Planning Application Ref: R/205/17/T

Location : rear of 10-12 Bushby Avenue, Rustington

Description of works: Prune back branches overhanging north boundary wall & roofing by 300-500mm to 1 No Sycamore tree

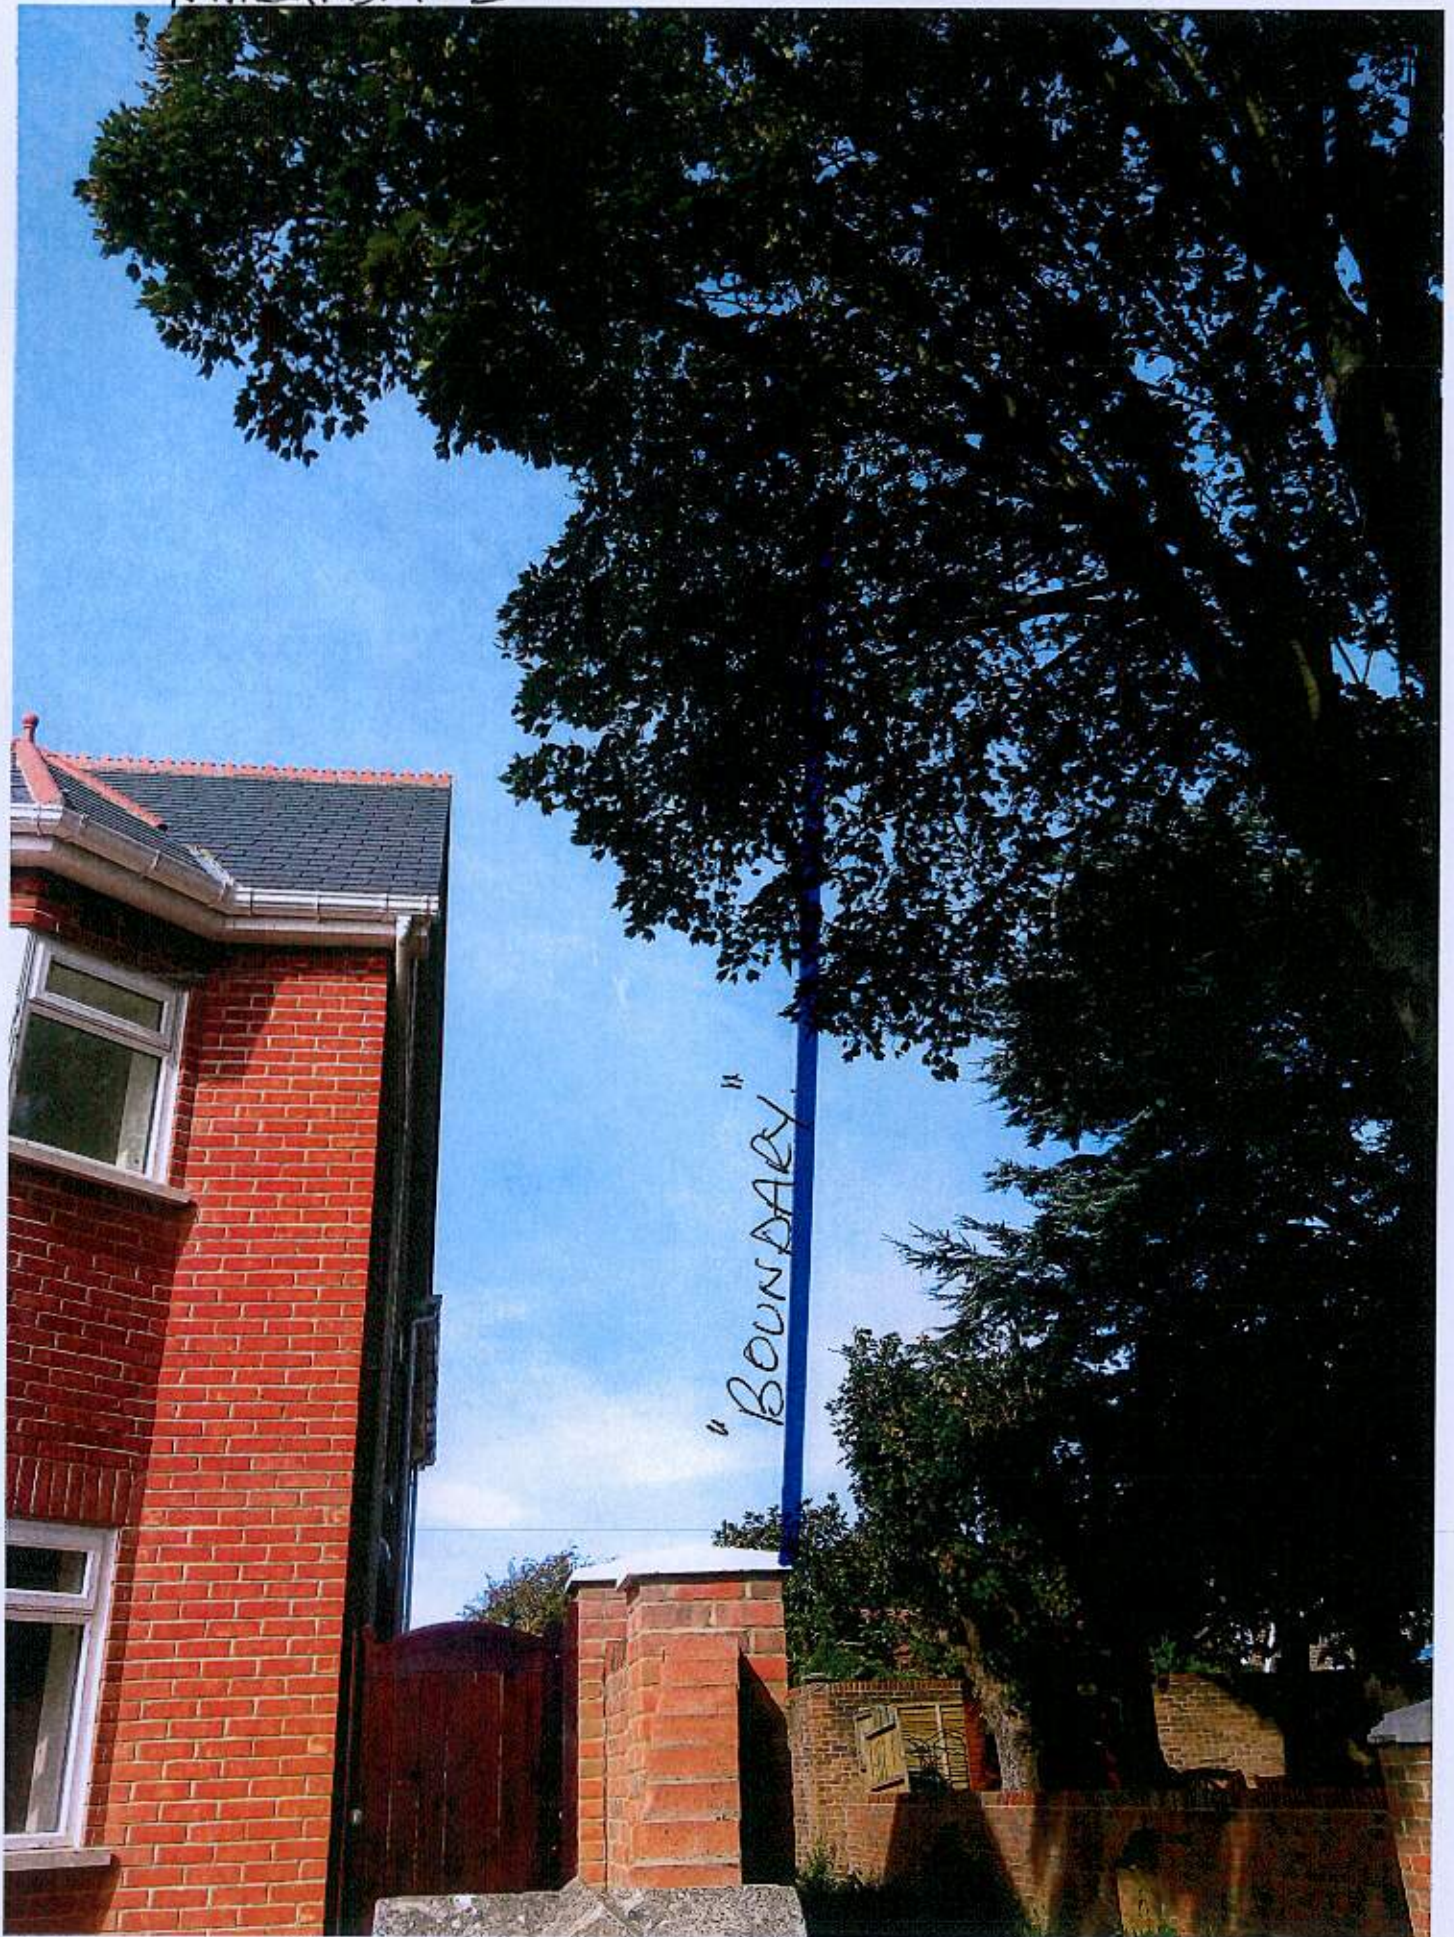
- The request to remove the overhanging growth by 300mm[1ft] to 500mm [1ft 7ins] is reasonable and acceptable but what concerns me is the level of prune shown by the line submitted on the photographs – if pruned back to this line then it would equate to 1m to 1.5m off the rear section of the tree and double that to the front section which would not be acceptable.
- I am happy to approve the minor level of pruning which has been requested but will be keeping an eye on this site to make sure that 500mm is not exceeded – this would of course be an offence under the Town and Country Planning Act and the tree surgeon and the person instructing them would be liable to prosecution.

- I recommend **APPROVAL** for the pruning back of branches (facing onto flank wall of 7 Waverley Rd) measured from the tips back towards the trunk by between 0.3m to a maximum of 0.5m.
- The owner's consent to prune the tree is not required **IF** the work is to be undertaken from a lift platform **but** if the tree surgeon has to climb the tree then they must first obtain the approval of the owner of the tree.

- Where branches are to be shortened back the final cuts are to be made at the correct angle shown in BS3998:2010 and adjacent to a live bud or lateral.
